2 Wooldridge Walk
Climping
Littlehampton
BN17 5TB
10 April 2019

RE: Mistletoe Farm - Horsemere Green Lane – Climping. (CM19/13/RES)

CM/37/18/OUT Outline application with some matters reserved for the redevelopment of site with 2 no. 4-bed detached bungalows & associated work (resubmission following CM/10/18/OUT). This application is a Departure from the Development Plan. Approved subject to Conditions.

1071/DPA05

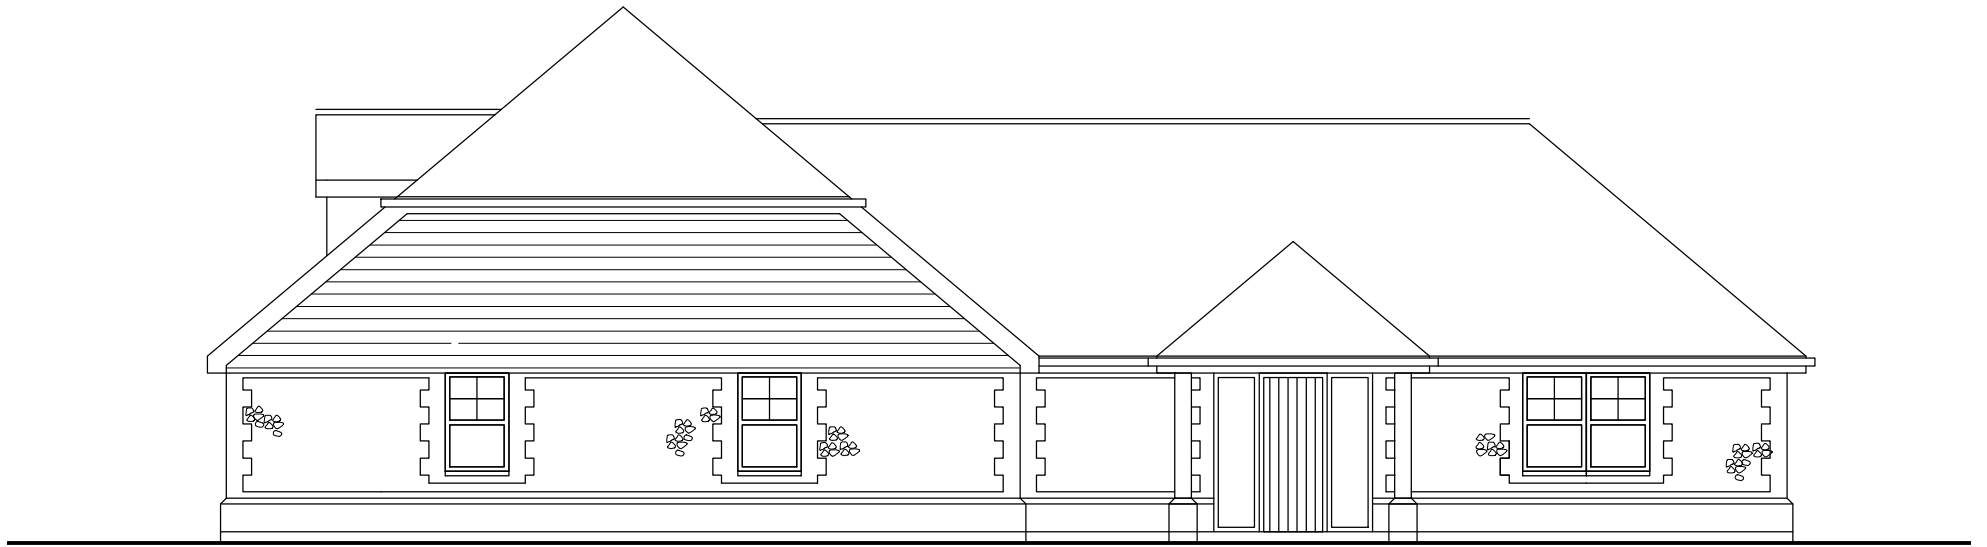
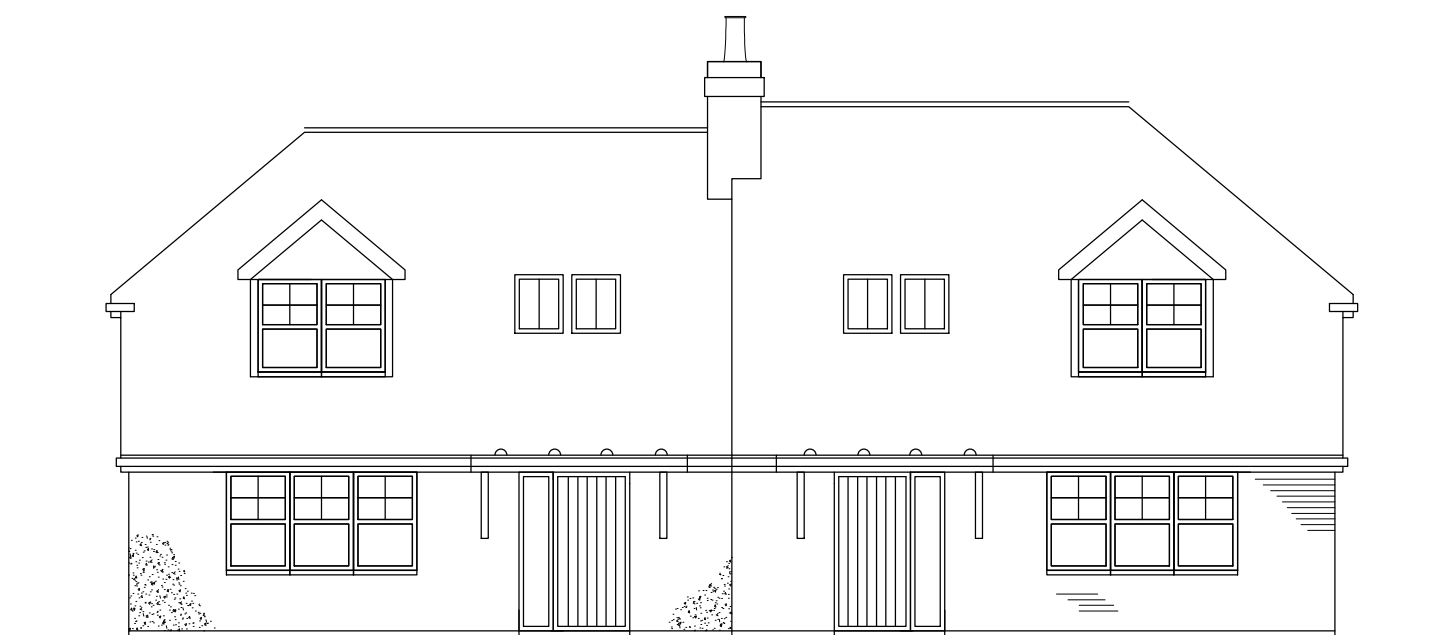
My property, a bungalow (**single-storey**) at No.2 Wooldridge Walk, sits on the Side Elevation (West) boundary of what is currently **Plot 2**, proposed for the erection of a **4-bedroom Bungalow**. The most recent detailed layout plans for approval (CM19/13/RES) lists **Plot 2** to be a **two-storey, Chalet Bungalow** dwelling. Looking at previous applications for this site, while design issues might be solved by revised proposals, these do not remedy the location and site problems when viewed from my **single-storey** home and garden. The proposed two-storey dwelling by virtue of its depth, height, associated bulk and design, would appear overbearing and visually intrusive to the occupiers of the adjacent properties when viewed from the rear windows and rear amenity areas. In addition, the size in relation to the plot, inadequate garden size, overlooking issues and impact on the locality all add up to the proposed siting of this development to be totally ill-considered and is out of keeping with the surrounding environment.

The front windows on the north facing elevation and the side facing first floor windows on the proposed west facing elevation would directly overlook the rear amenity areas of my home which would create an unacceptable degree of overlooking, thus causing a loss of privacy and would be detrimental to the amenities enjoyed by the occupiers of this property.
